<b>Consultation Response from KC, Conservation and Design</b>
<b>2021/92206 Land Off, Woodhead Road, Brockholes, Holmfirth</b>
<b>Erection of 137 homes with open space, landscaping and associated infrastructure</b>
<b>Date Responded: 25.03.2022</b>
<b>Responding Officer: Nick Grimshaw</b>
<b>Responding Ref:</b>

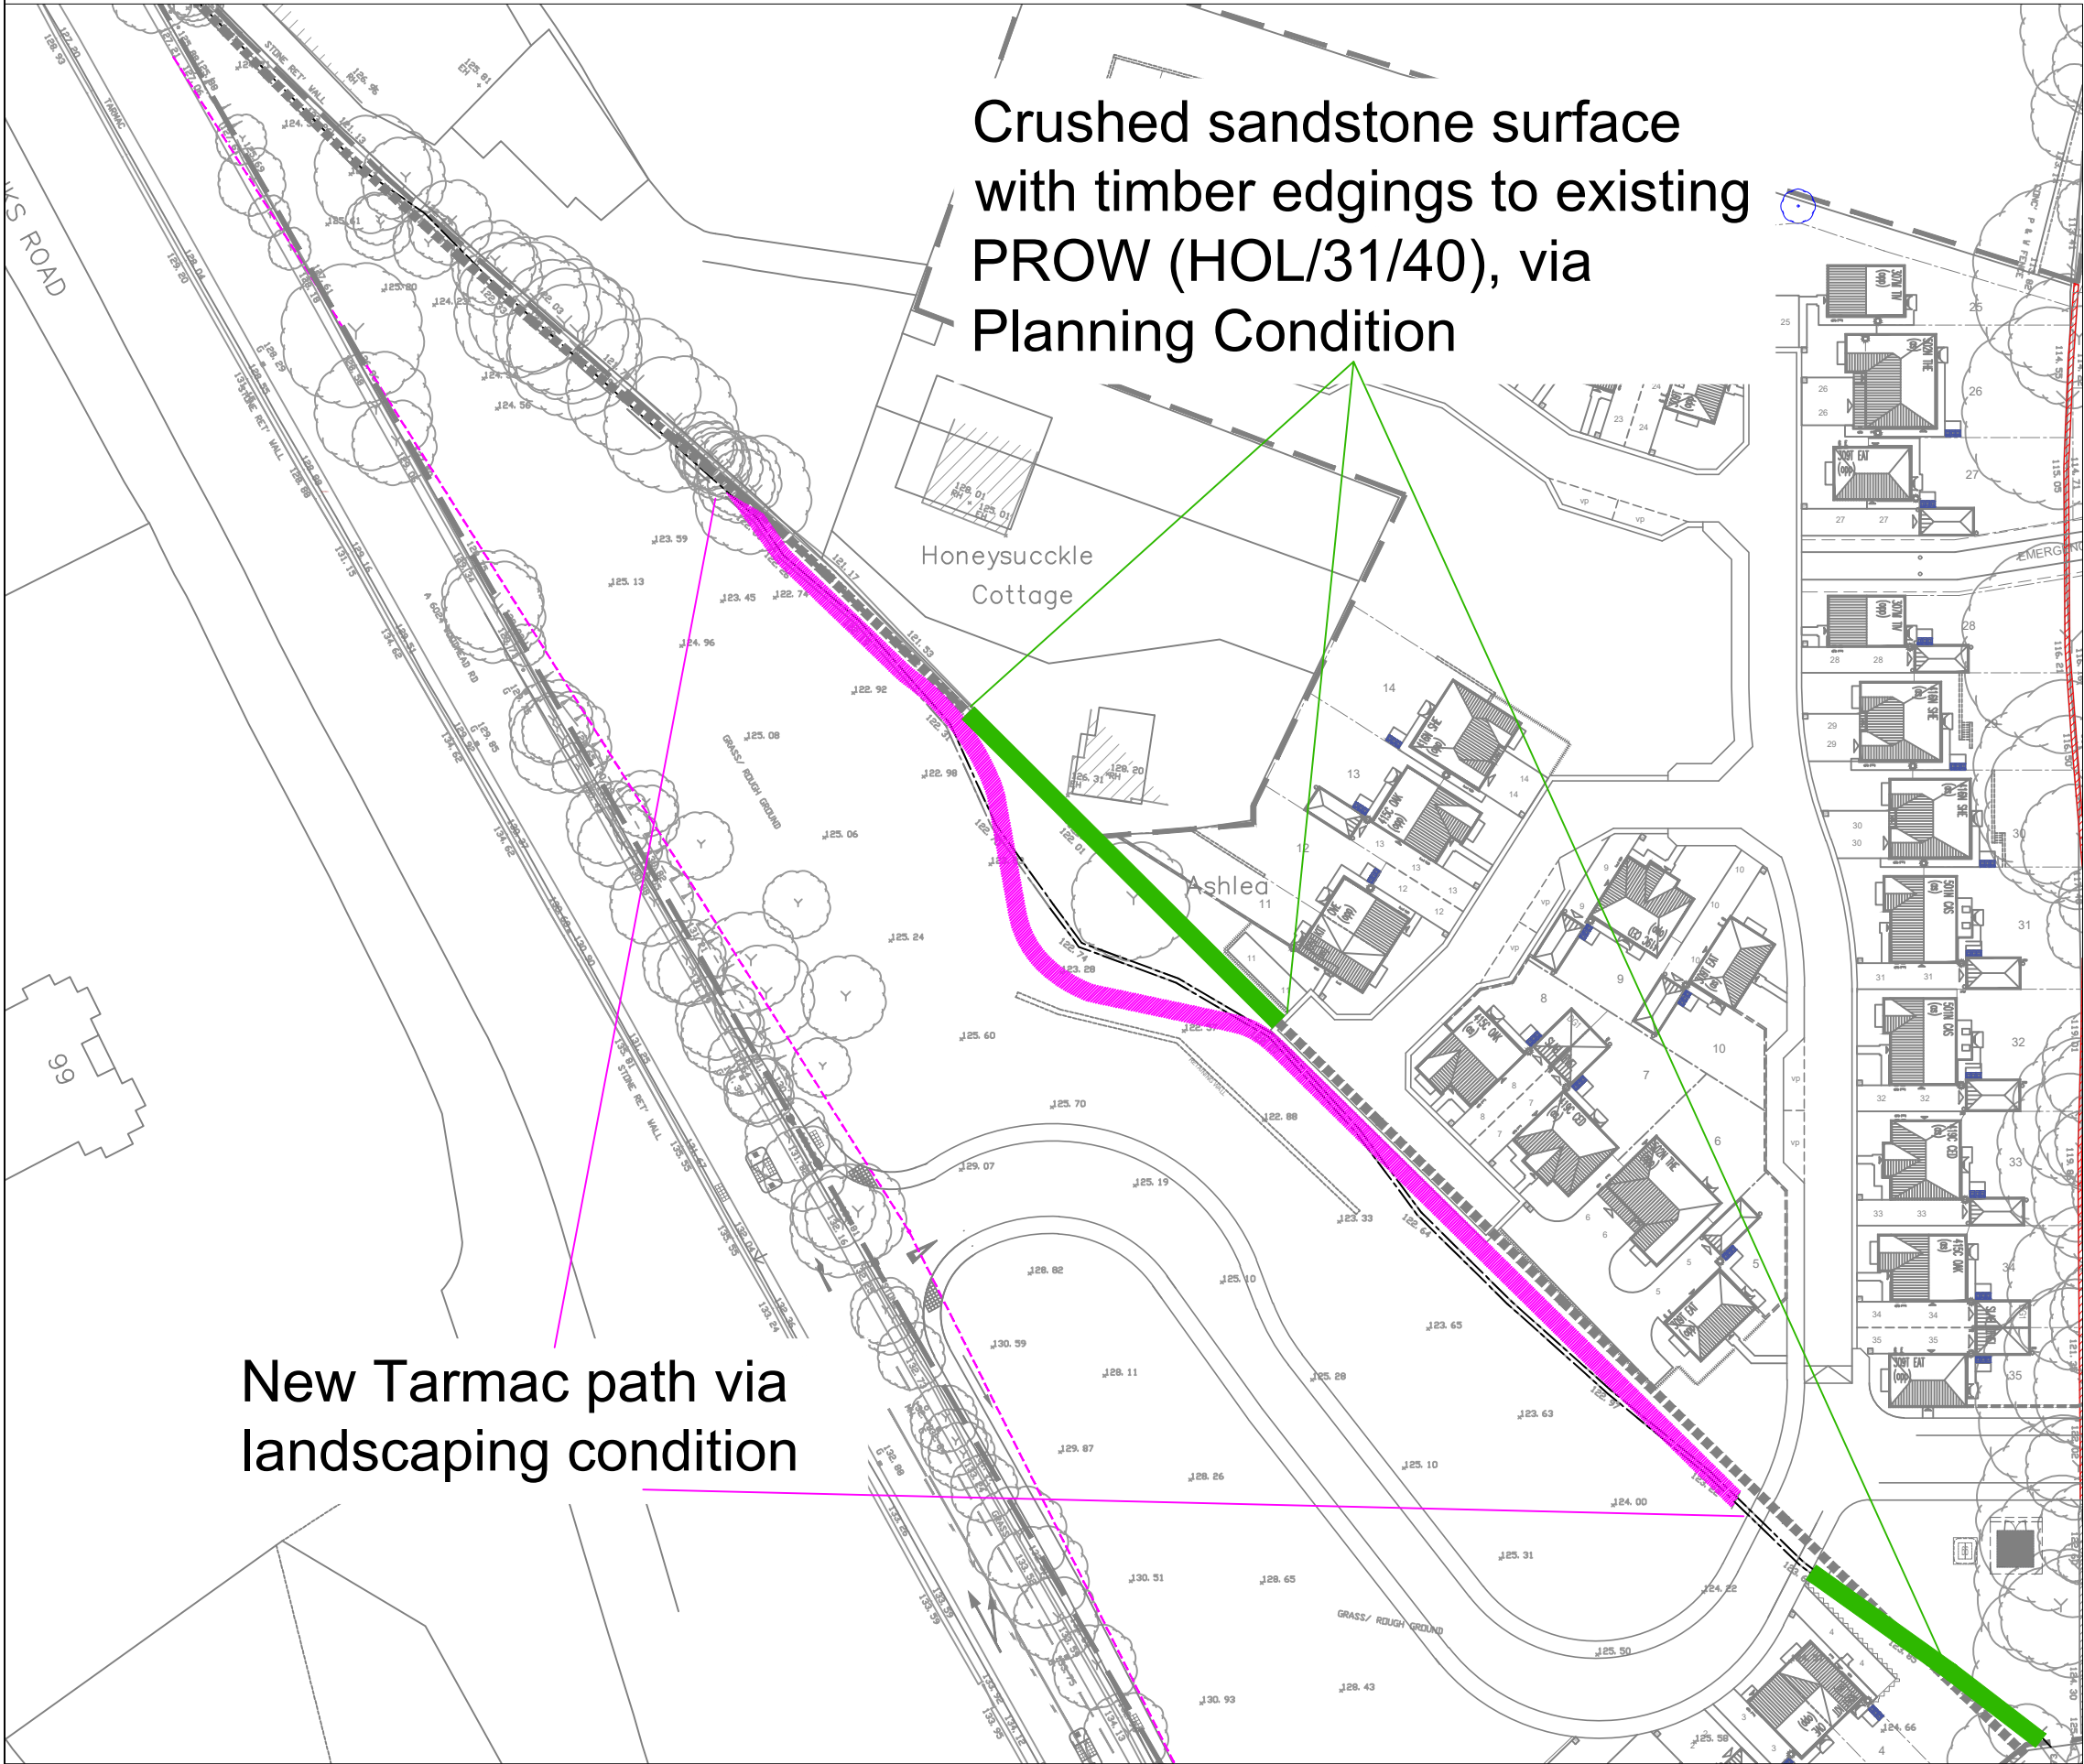
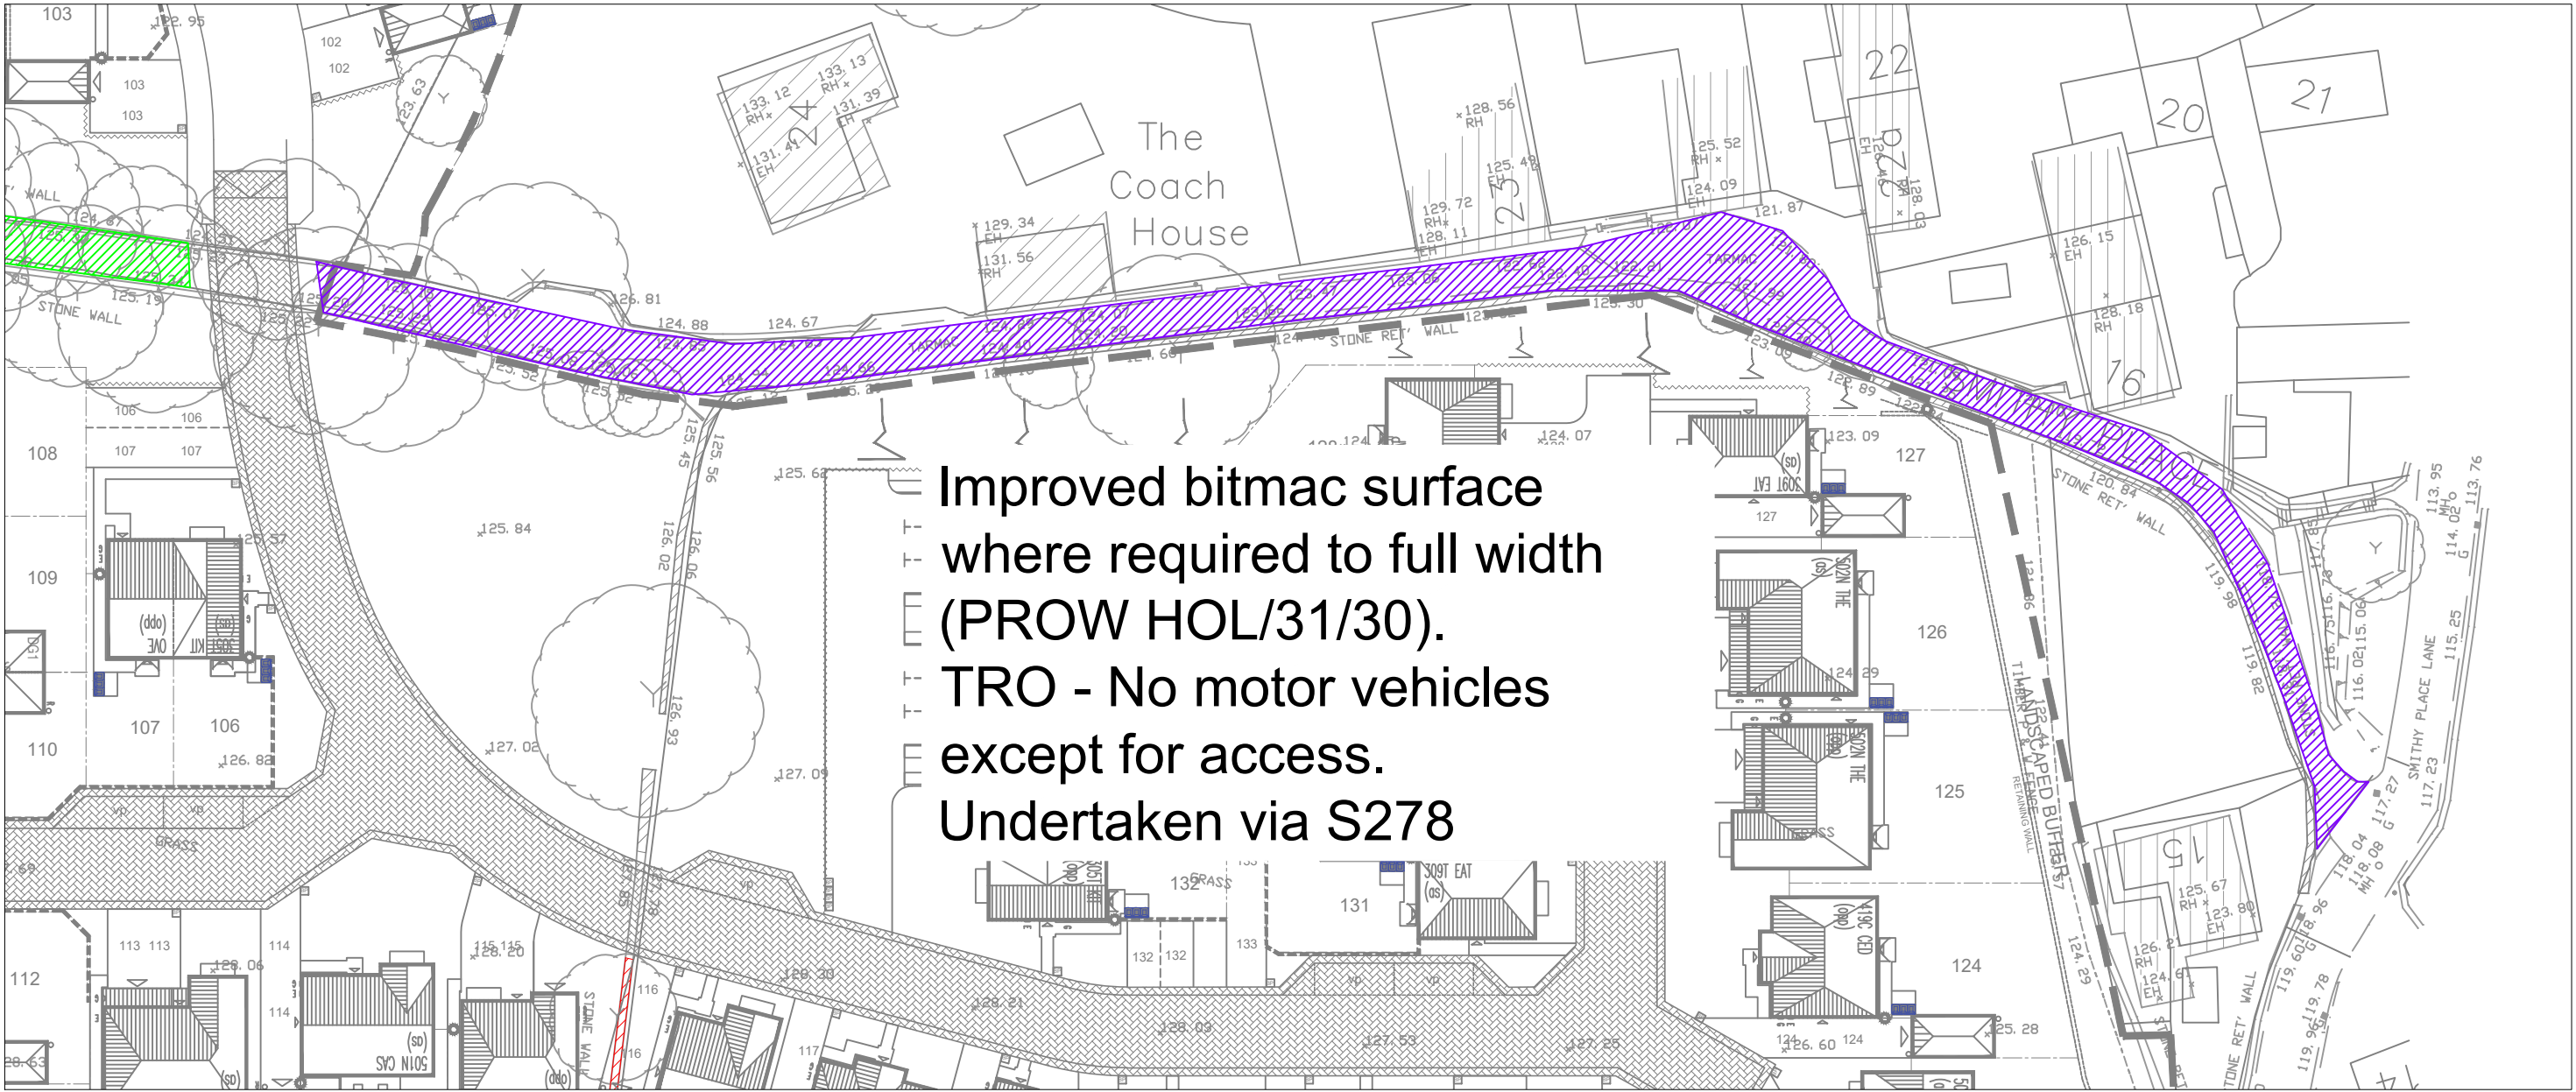
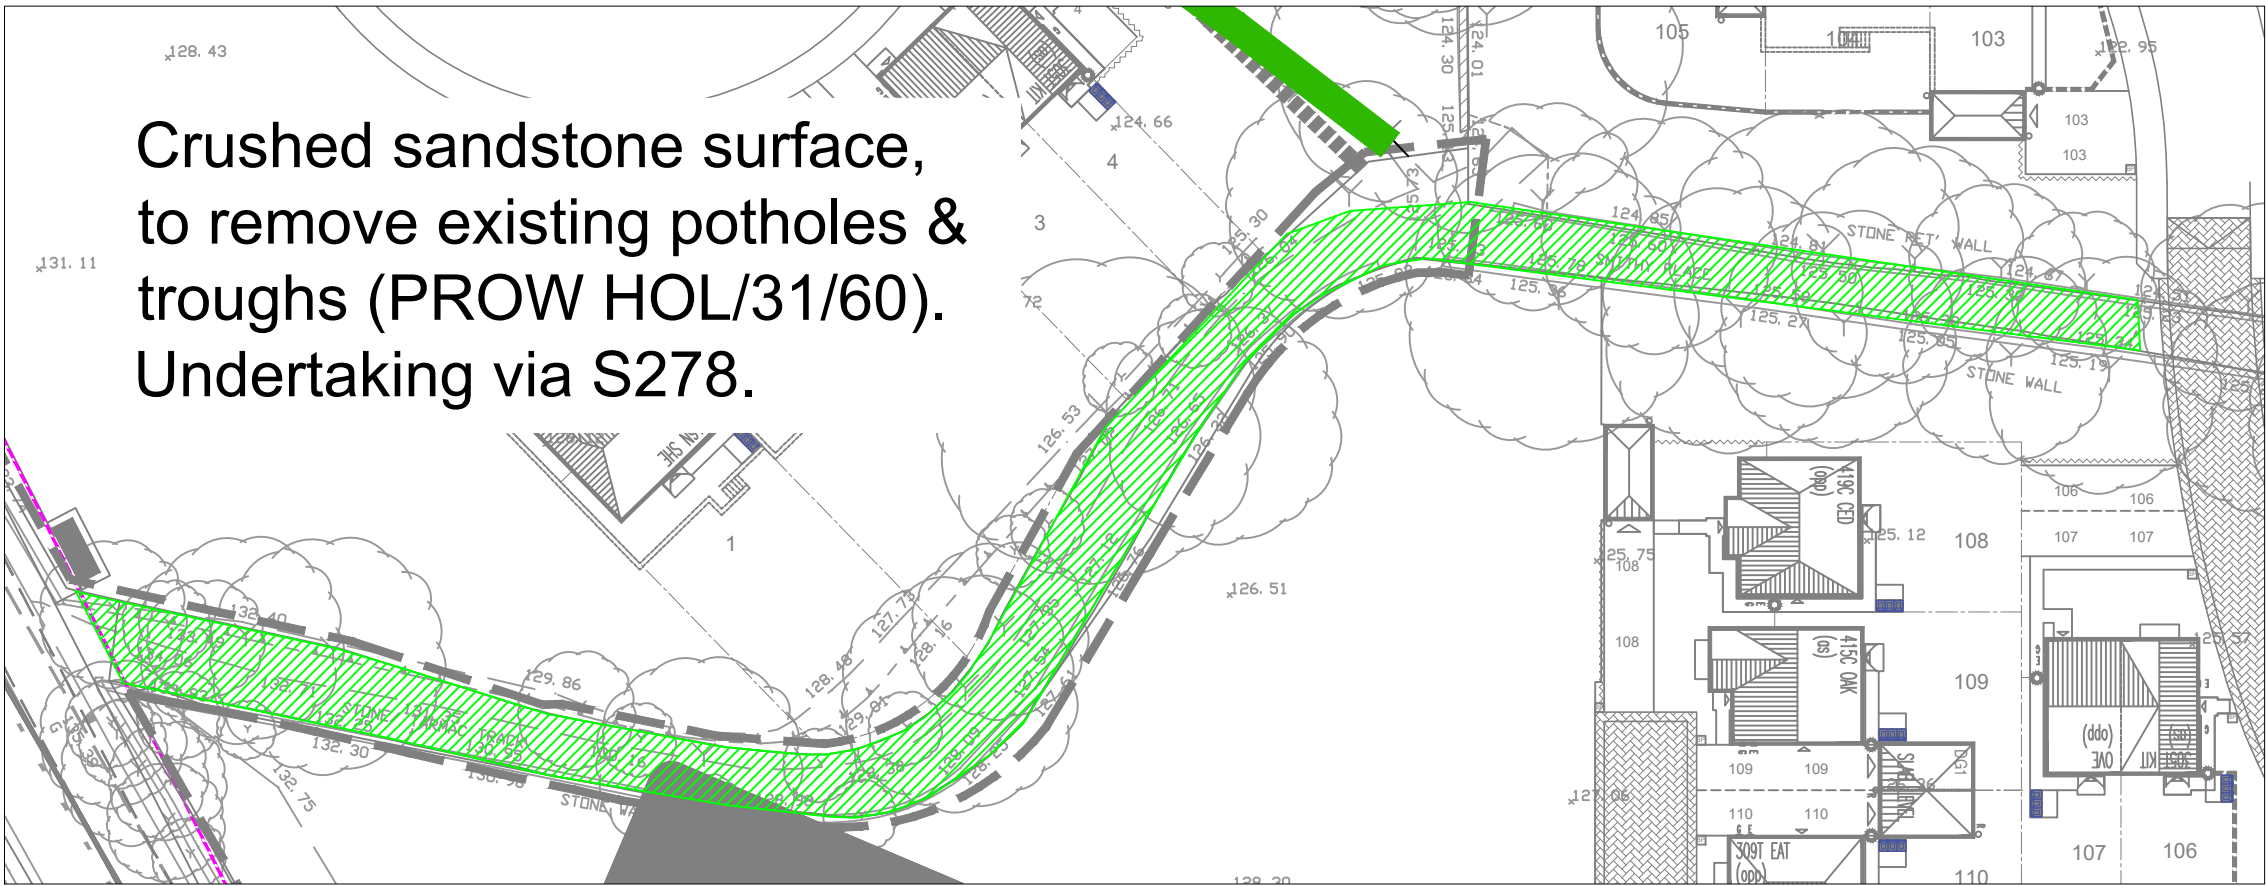
- 2.4 The historic public rights of way which cross the site from Woodhead Road remain poorly integrated into the proposed layout (HOL/31/40 and Smithy Place-HOL/31/60) and become incidental, rather than integral, to the design solution. In the case of HOL/31/40 the character of the PROW as an access across the fields continues to be part of the hammerhead turning to access units 11, and 5 – 8.

- 2.5 The proposed POS is also poorly integrated into the design solution and would be dominated by main access roads, the embankment to Woodhead Road, and hard surfaced turning areas (such as adjacent to units 119 – 122. Similarly, the proposal for the area flanking the River Holme would be characterised by blank gables with no obvious physical or visual connections

to the enclosing space. The character and use of the open-space would be continue to be compromised by the boundary fences of the east side of the development with little natural surveillance, or even clear access, to identify the POS as part of the housing layout.

- 2.6 The revisions have retained some important tree groups, but the new road layout continues to fail to provide any new street trees as required by NPPF paragraph 131. The potential to enhance or reflect the site's key characteristic defined by the enclosing tree groups has not been addressed.
- 2.7 The proposed main north-south access road remains focused on the pumping station which would be an unfortunate terminus to this streetscape. This spinal street would also continue to be dominated by hard-surface, frontage car-parking, with no integration of street trees.
